From: Renzo Arango **Date:** 18 Feb. 15 **File No:** S30229\001\W-121\ca150217s0019 **Pages:** 3
Project: Hornsby Ku-Ring-Gai Chase Hospital - Acoustics Consultancy Services **No:** J-030[1.0]

Acoustics – Assessment of Stand-by Generator

Service Yard
1:100
WHLAR MW 1011

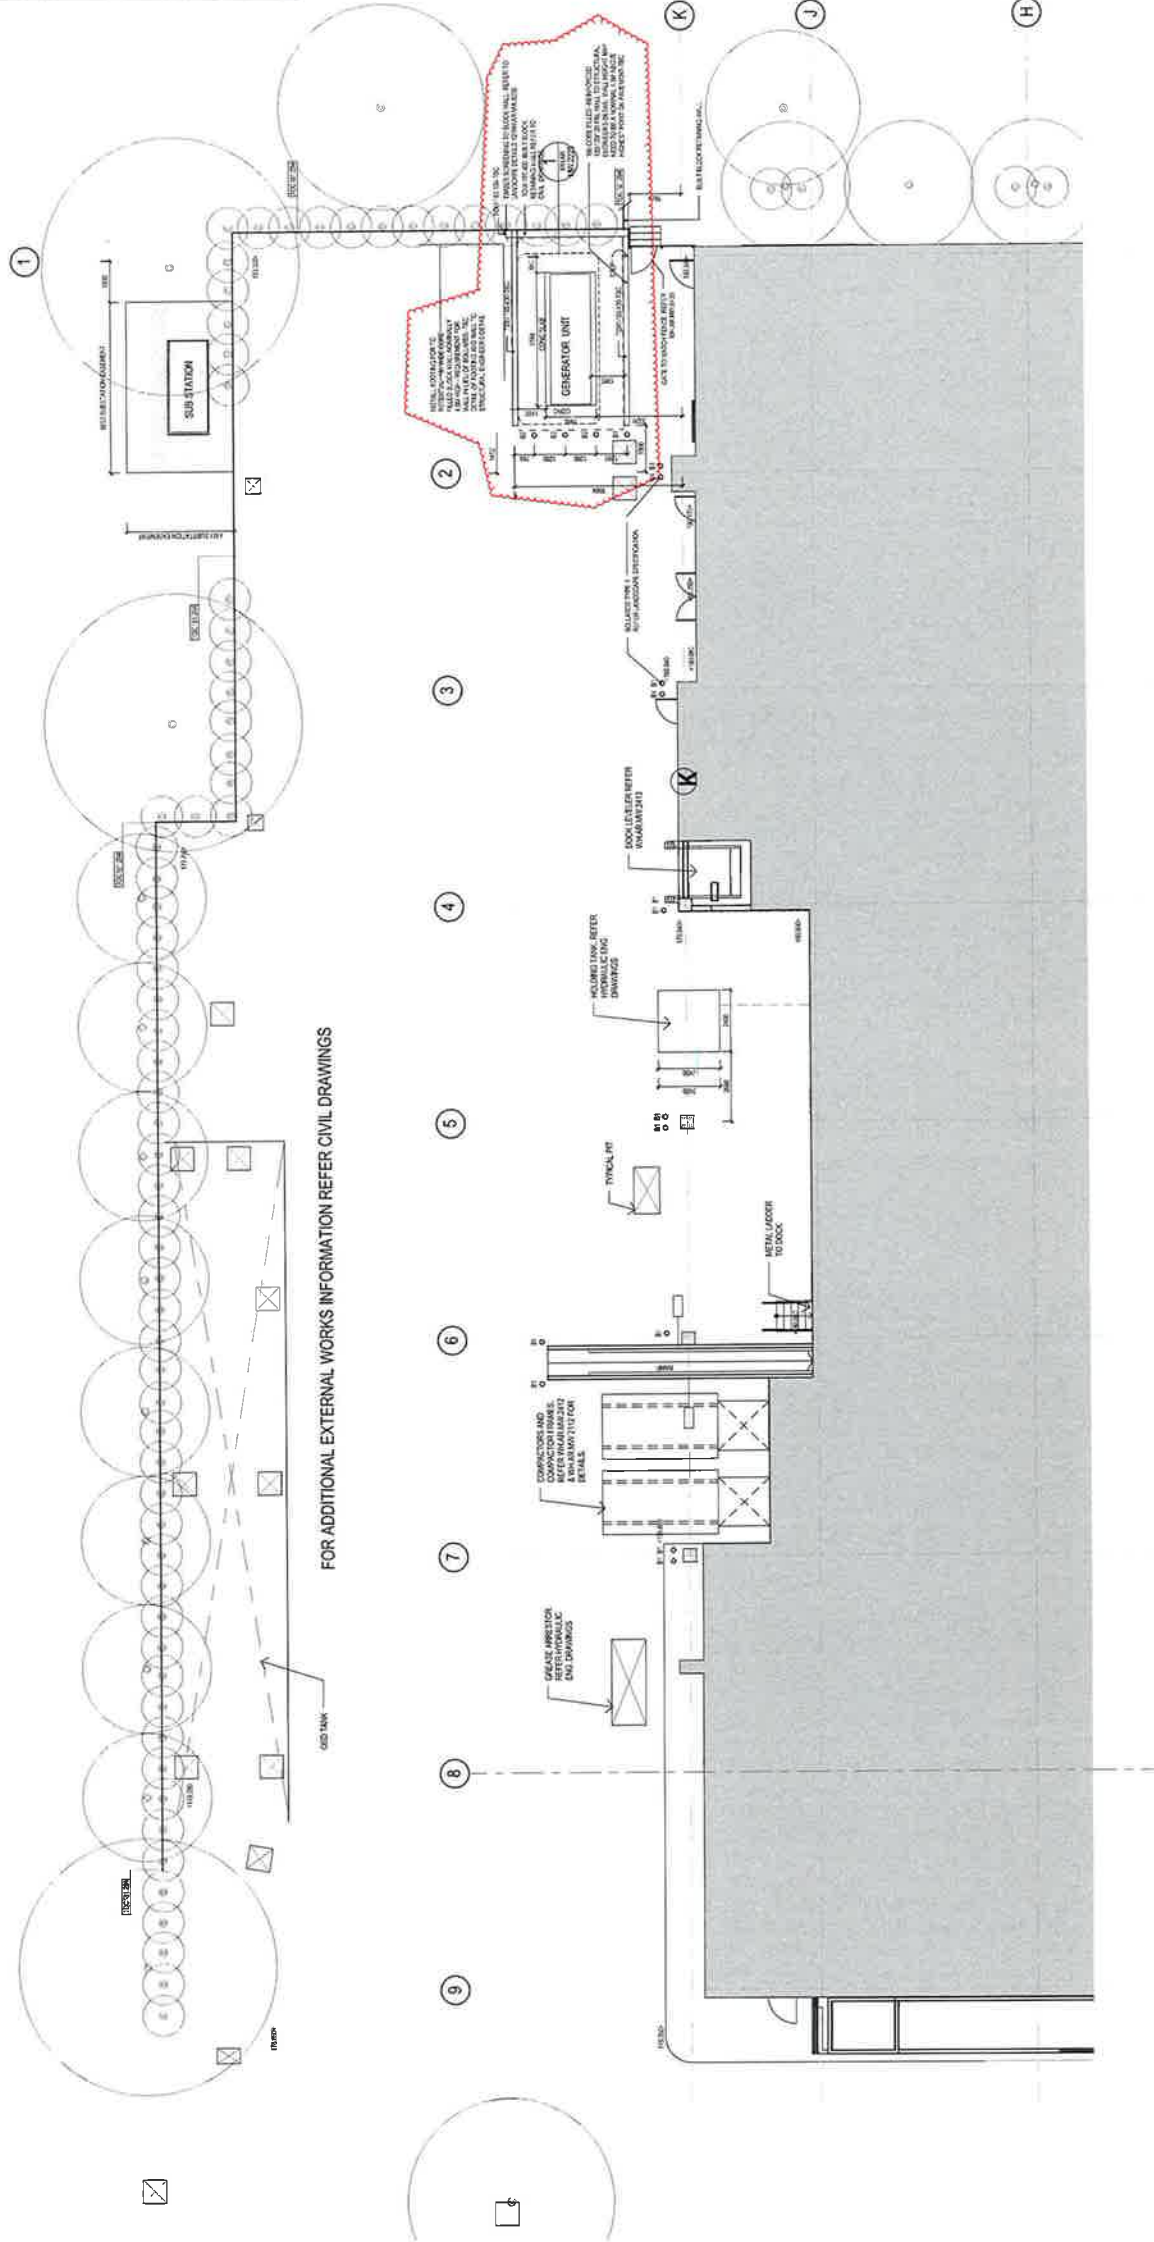
- The location, extent and height of the noise barrier shown in Figure 1 is acceptable to meet the compliance condition for maintenance operation only. This is on the basis that the barrier treatment is as per recommendations discussed in NDY correspondence J-028 ca150202s0021 and the operation of the plant for maintenance is as per Section 8 of the NDY Detailed Design Acoustic Report (refer also to Aconex Correspondence RCC-GCOR-004628, dated 29th January 2015).
- The barrier construction should achieve a minimum sound insulation performance of 40 dB R_w as outlined in CAN J-028.

- It is recommended that the generator should be oriented in such a manner that the exhaust and air discharge are aimed away from Burdett Street (refer to Figure 1). It is also advised that based on the height of the noise barriers noted above, that the exhaust should be aimed vertically (i.e. upwards).
